**Application No:** 18/00039/DISC

**Proposal:** Discharge of condition 19 (materials and finishes), 23 (bus stops), 59 (Construction Management Travel Plan) of 10/01780/HYBRID.

**Location:** Bicester Eco Town, Exemplar Site, Banbury Road, Bicester.

## **Transport Development Control**

PROJECT TITLE BICESTER ECO TOWN EXEMPLAR SITE		Drawing No. AA2699C/1.1/120		Rev B
DRAWING TITLE Phasing plan		Scale 1:1250	Date July 2012	Author [Redacted]

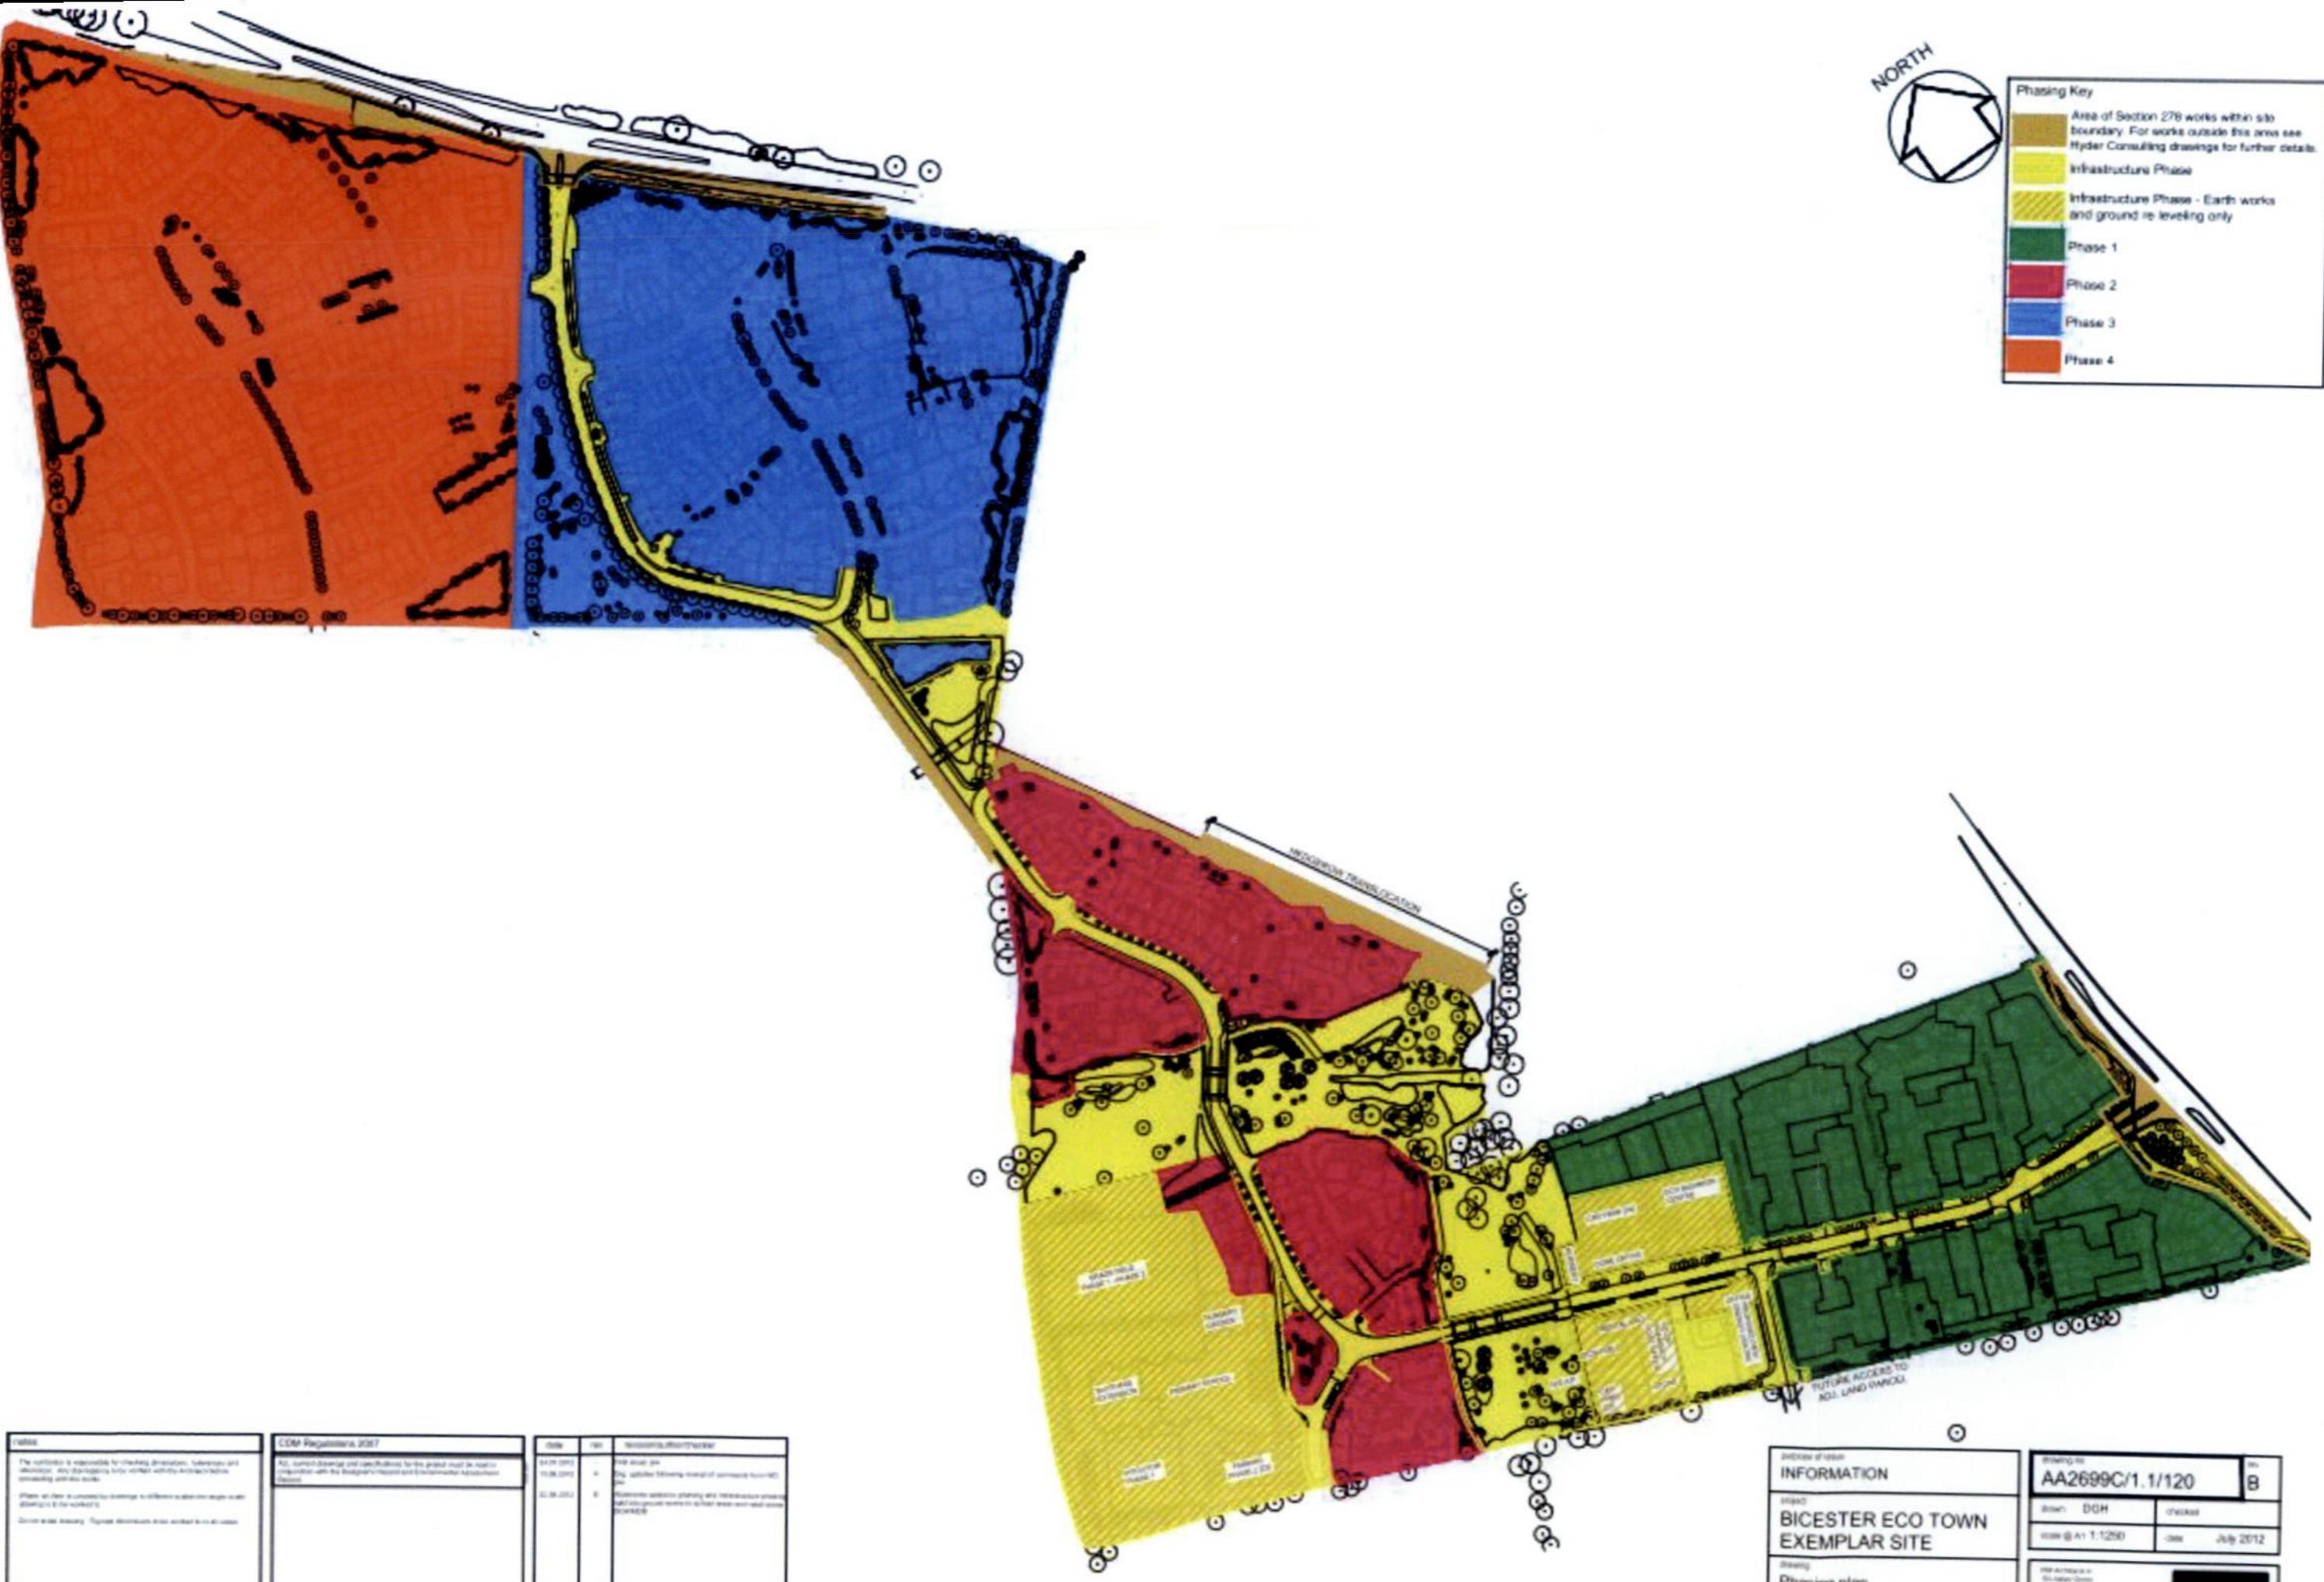
- Details of and approval of any traffic management needed during construction.
- Details of wheel cleaning/wash facilities – to prevent mud etc, in vehicle tyres/wheels, from migrating onto adjacent highway. **There is a rather loose commitment to wheel washing but a wheel washing bay is not shown on the plan. There must be a firm commitment to sweep up any debris transported onto the highway immediately, using a suction sweeper.**

- Layout plan of the site that shows structures, roads, site storage, compound, pedestrian routes etc. **The plan needs to state how many parking spaces will be provided on site and demonstrate that this will be sufficient. There must also be a commitment for site staff, operatives and contractors to park within the site and not on the highway.**

Title: SPINE ROAD (S38) GENERAL ARRANGEMENT SHEET 1 OF 4

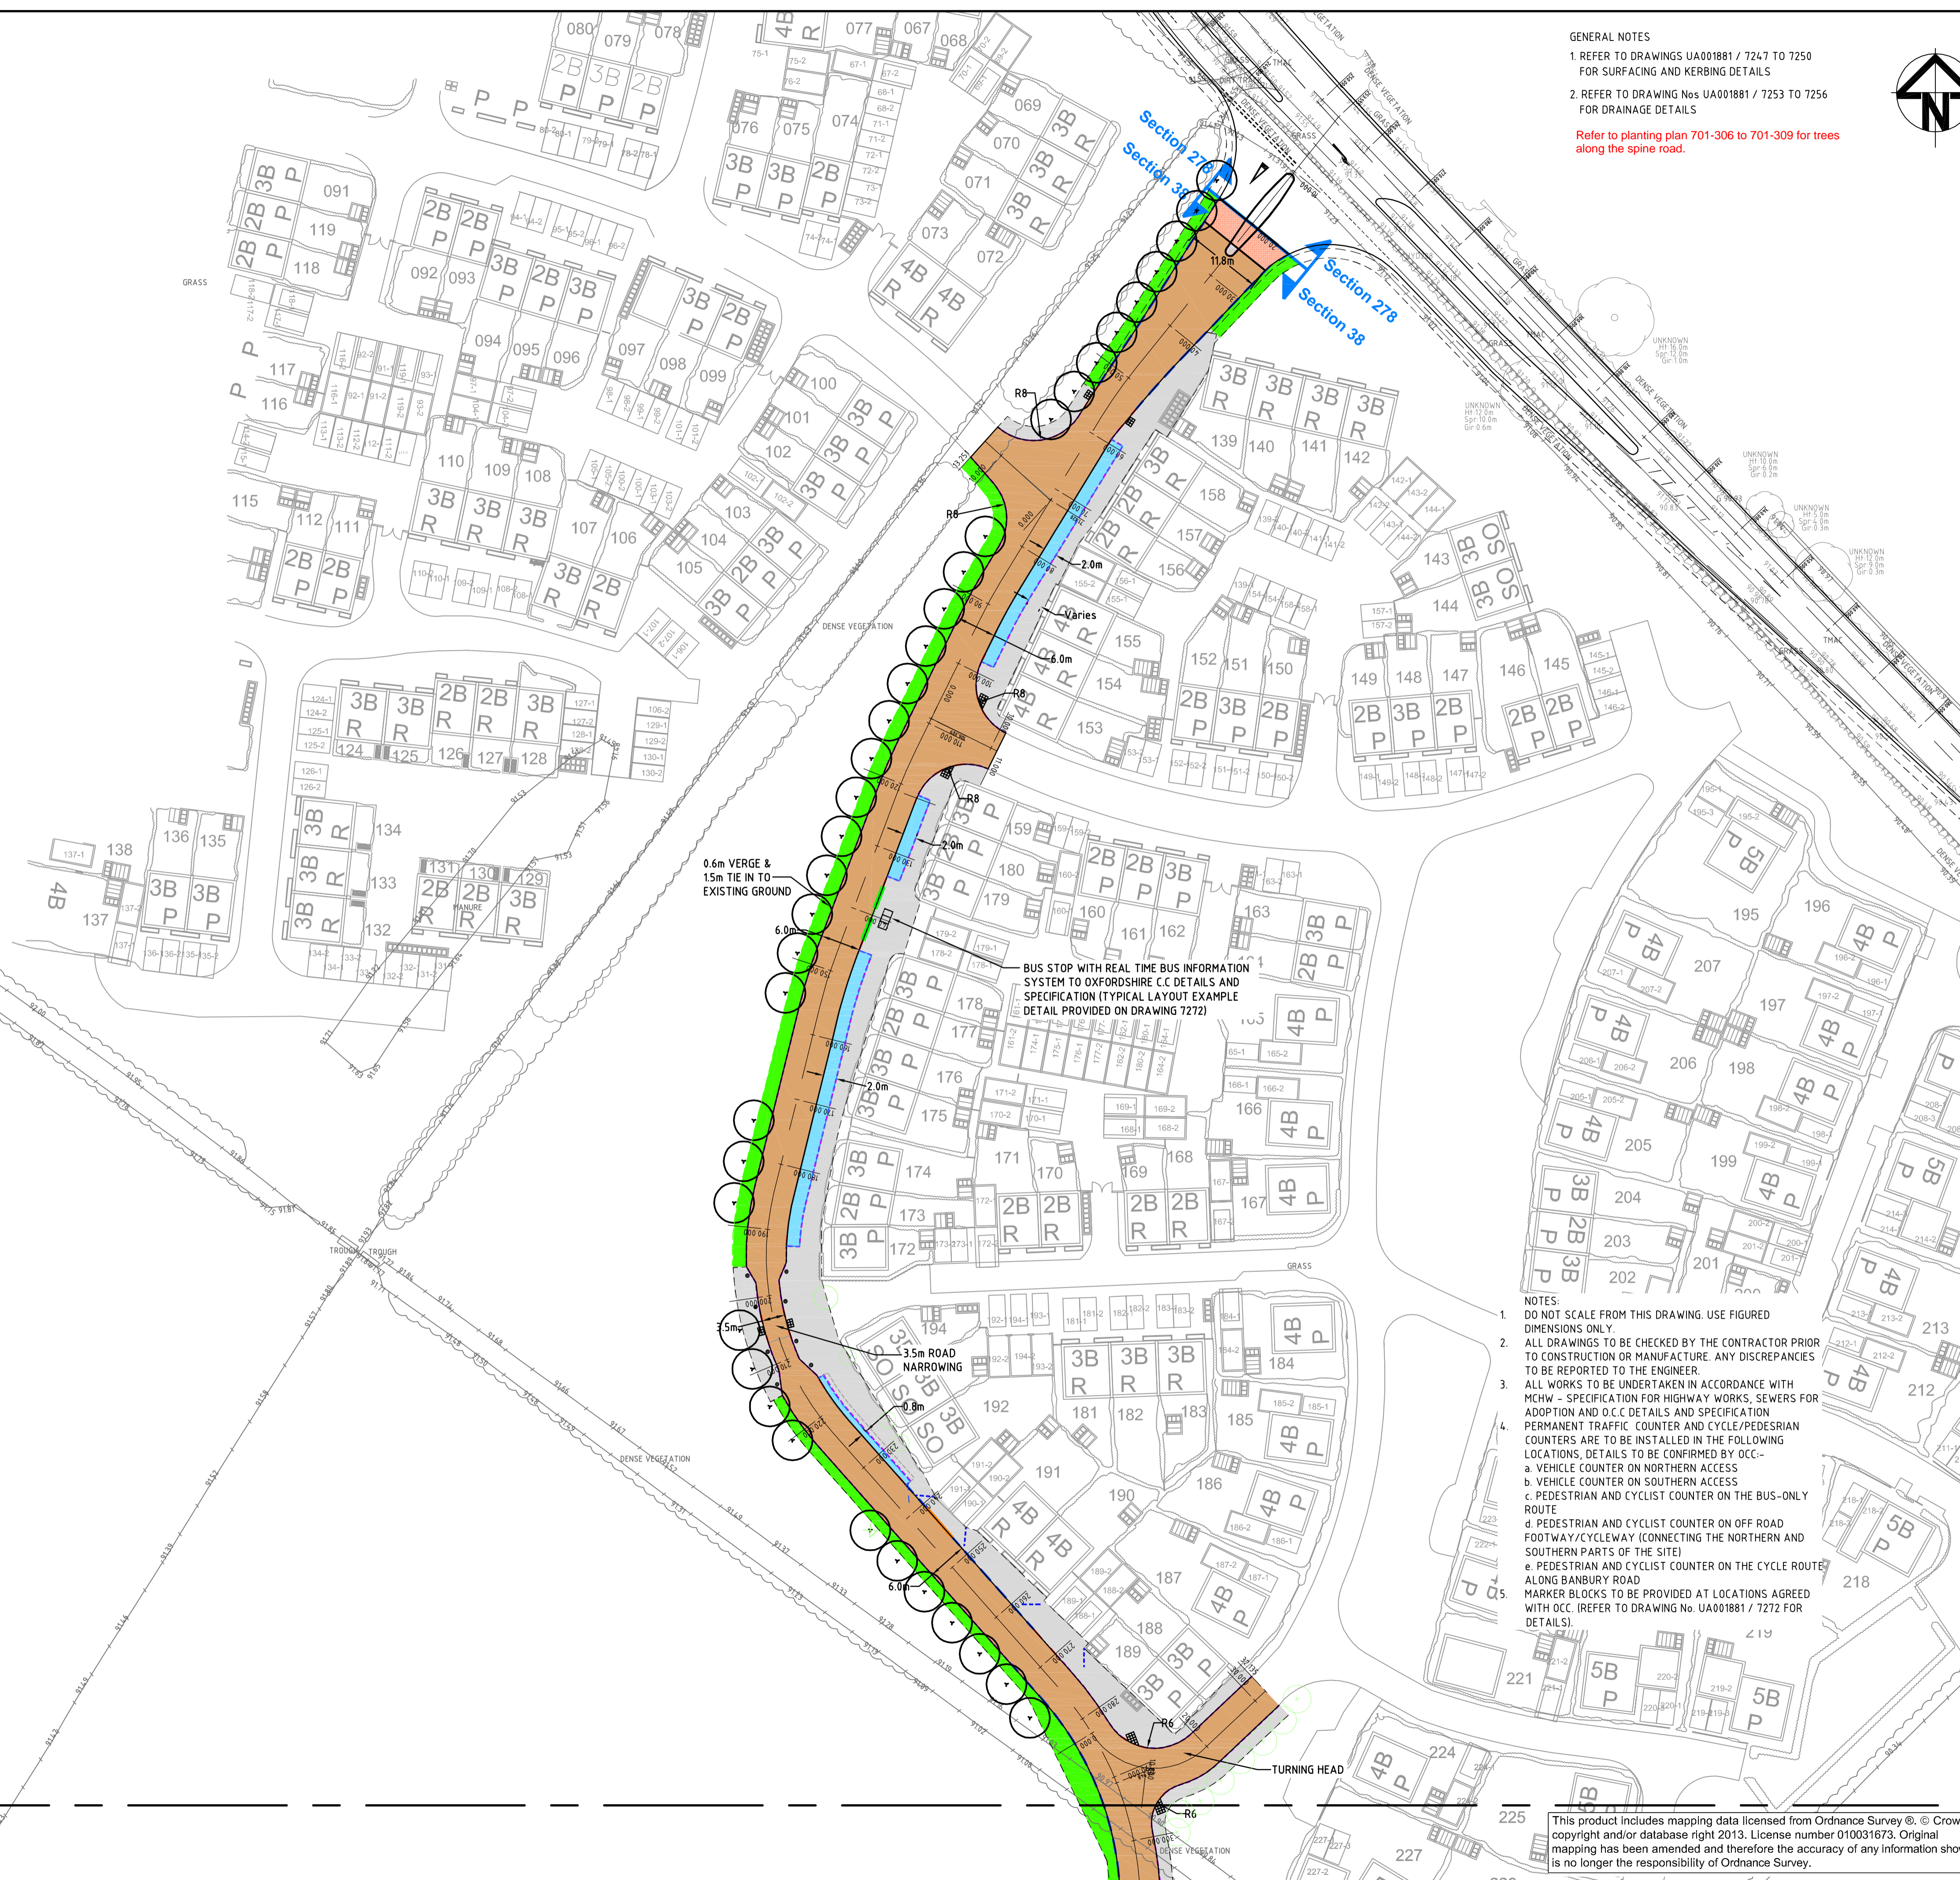
One bus stop is to be provided in this phase in the southerly direction. The location is correct, as agreed. It is noted that the S38 for this phase already has technical approval.

However, I am not clear that Bicester Town Council has approved the shelter type and agreed to take on its maintenance. It should not be procured or installed until this has been confirmed.

The condition requires a programme of delivery for the bus stops (which cannot be agreed until the above query is resolved), so until that is provided, OCC objects to the discharge of this condition.
